Meeting:	Hillingdon Planning Committee	
Date:	11th June 2025	Time: 7:00pm
Venue:	Committee Room 5, Civic Centre

ADDENDUM SHEET

Item: 8	Location: 42 The Larches
<i>Amendments/Additional Information:</i>	<i>Officer Comments:</i>
N/A	N/A
Item: 9	Location: 14-18 Field Heath Road & 2 Field Heath Avenue
<i>Amendments/Additional Information:</i>	<i>Officer Comments:</i>

Project Nr.	Drawing Nr.	Revision
SDU-104	201	K
Date 25.06.2024	Drawn	Scale 1:200@A1

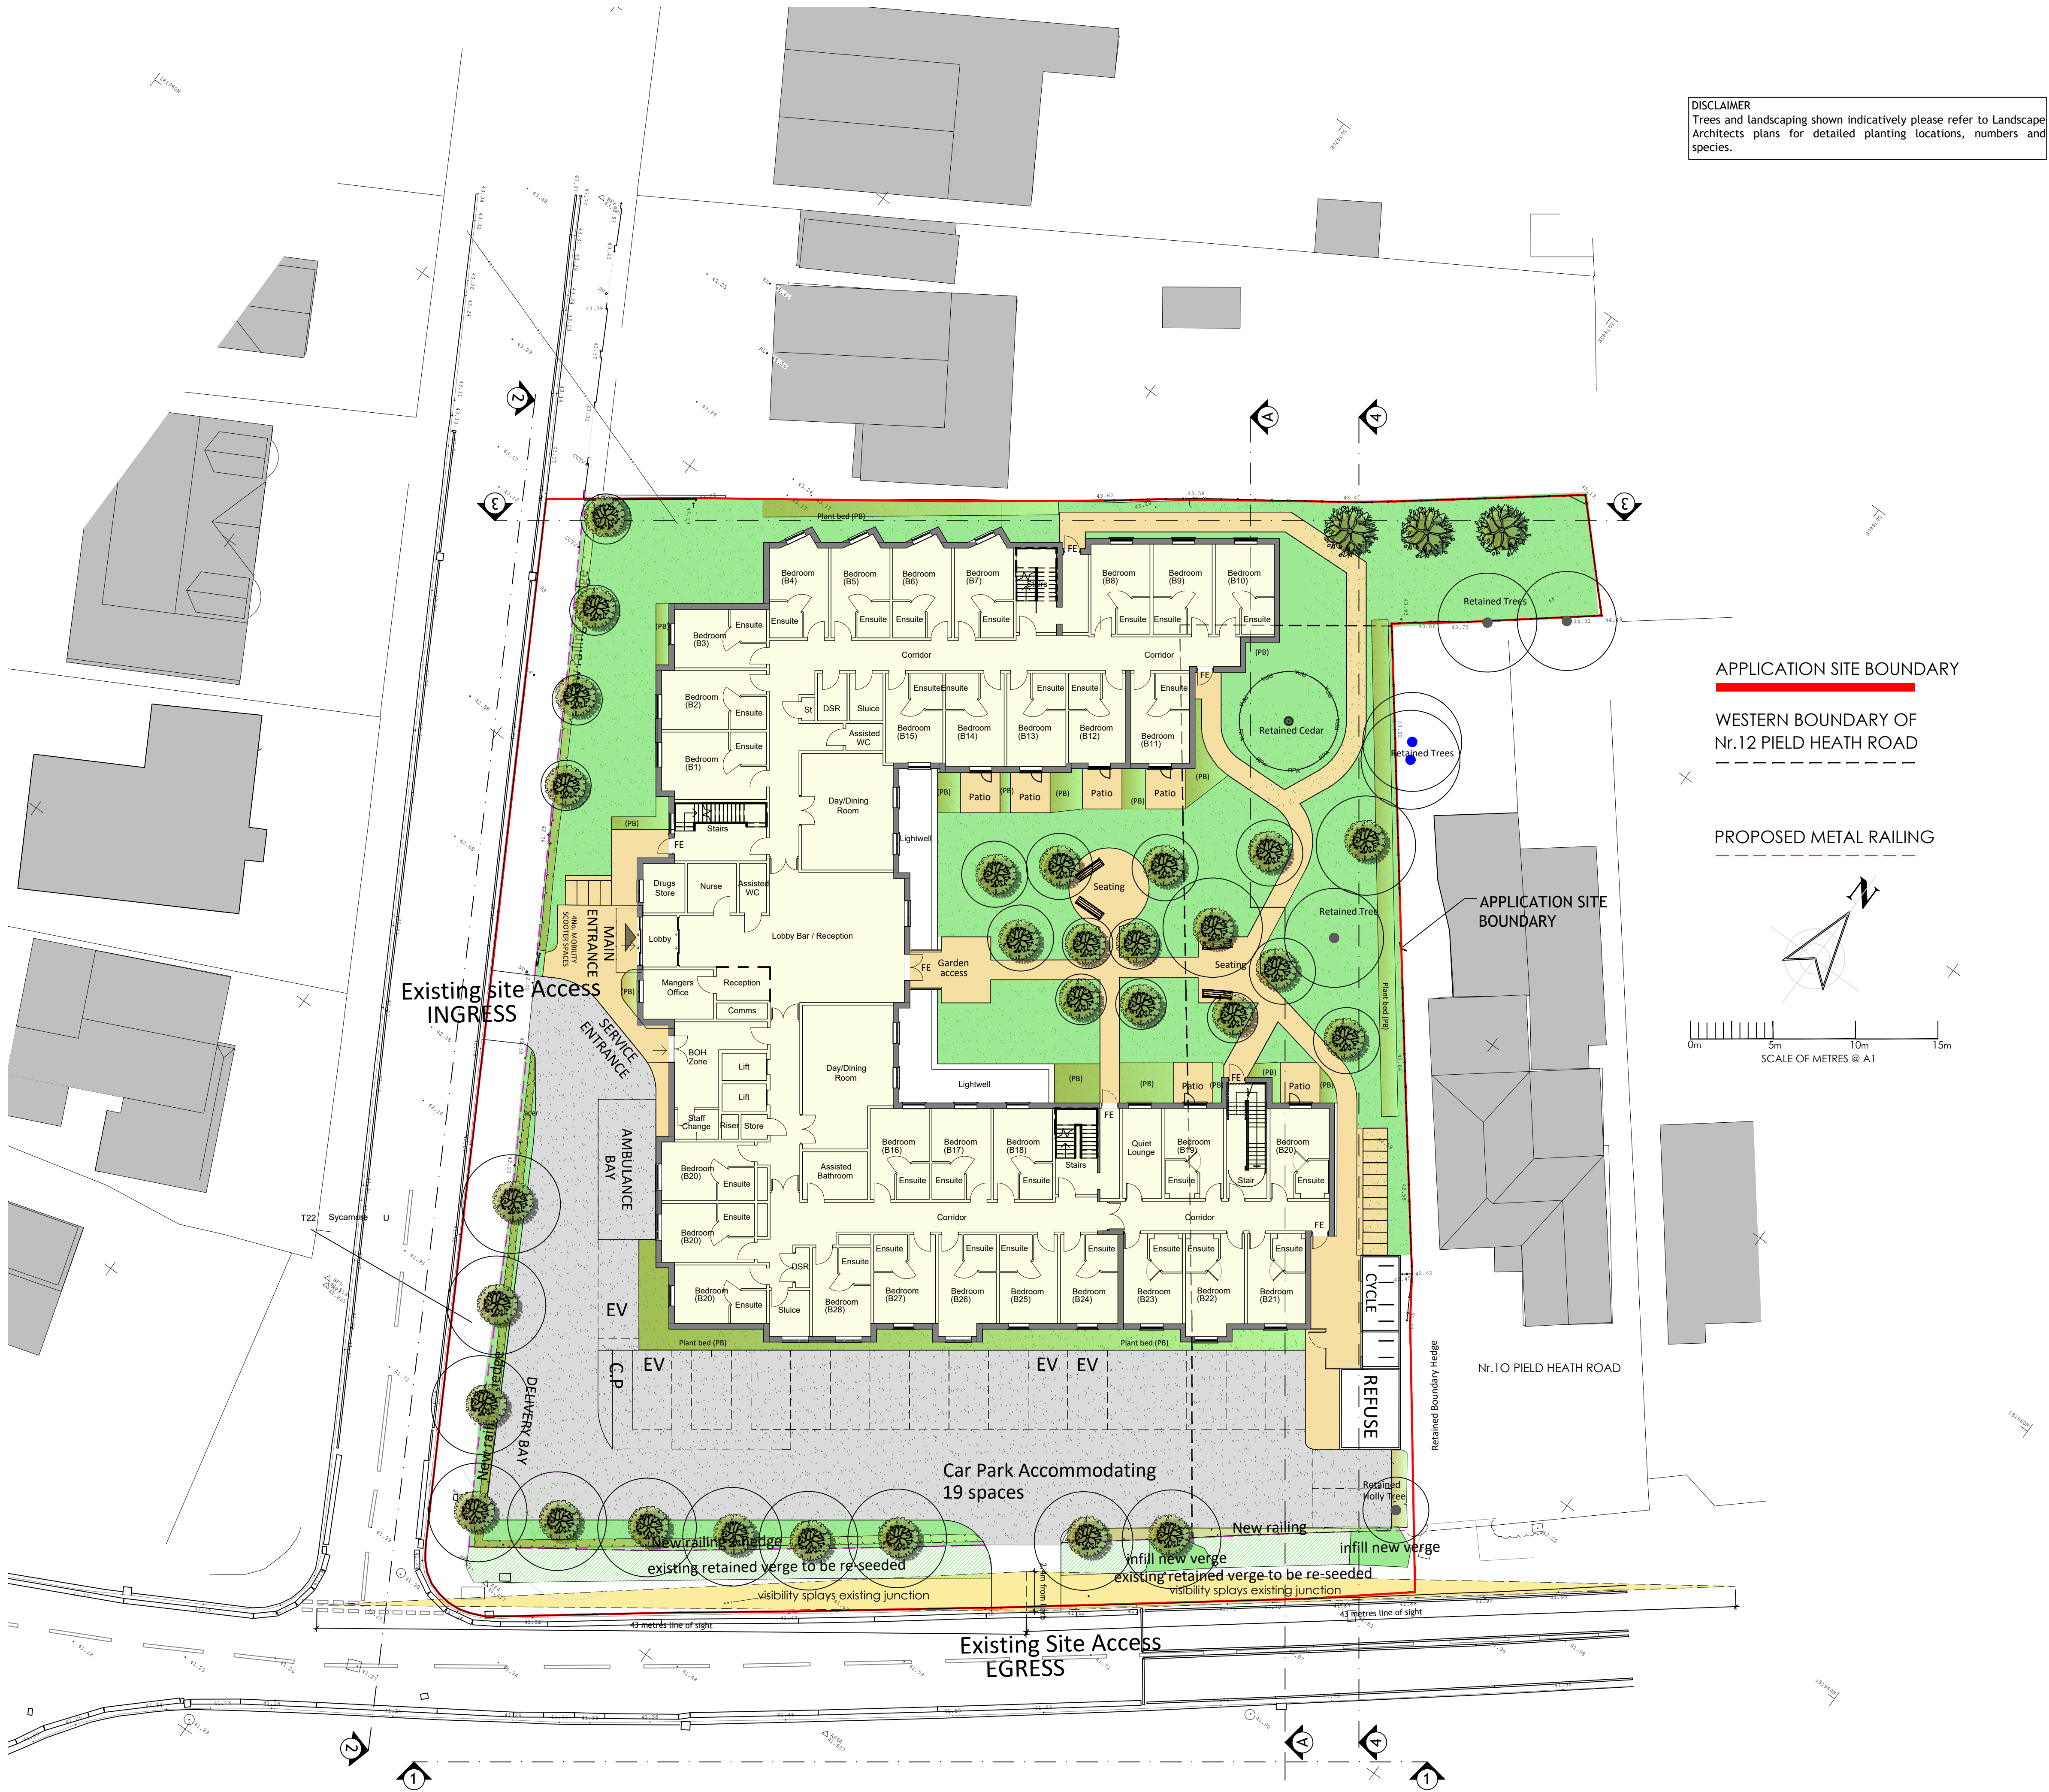
1. Amend Condition 2 (Approved Plans) references SDU-104 201 J to SDU-104 201 K .	Updated Landscape Strategy, incorporating the agreed final changes to trees (including the retention of the Cat A tree).
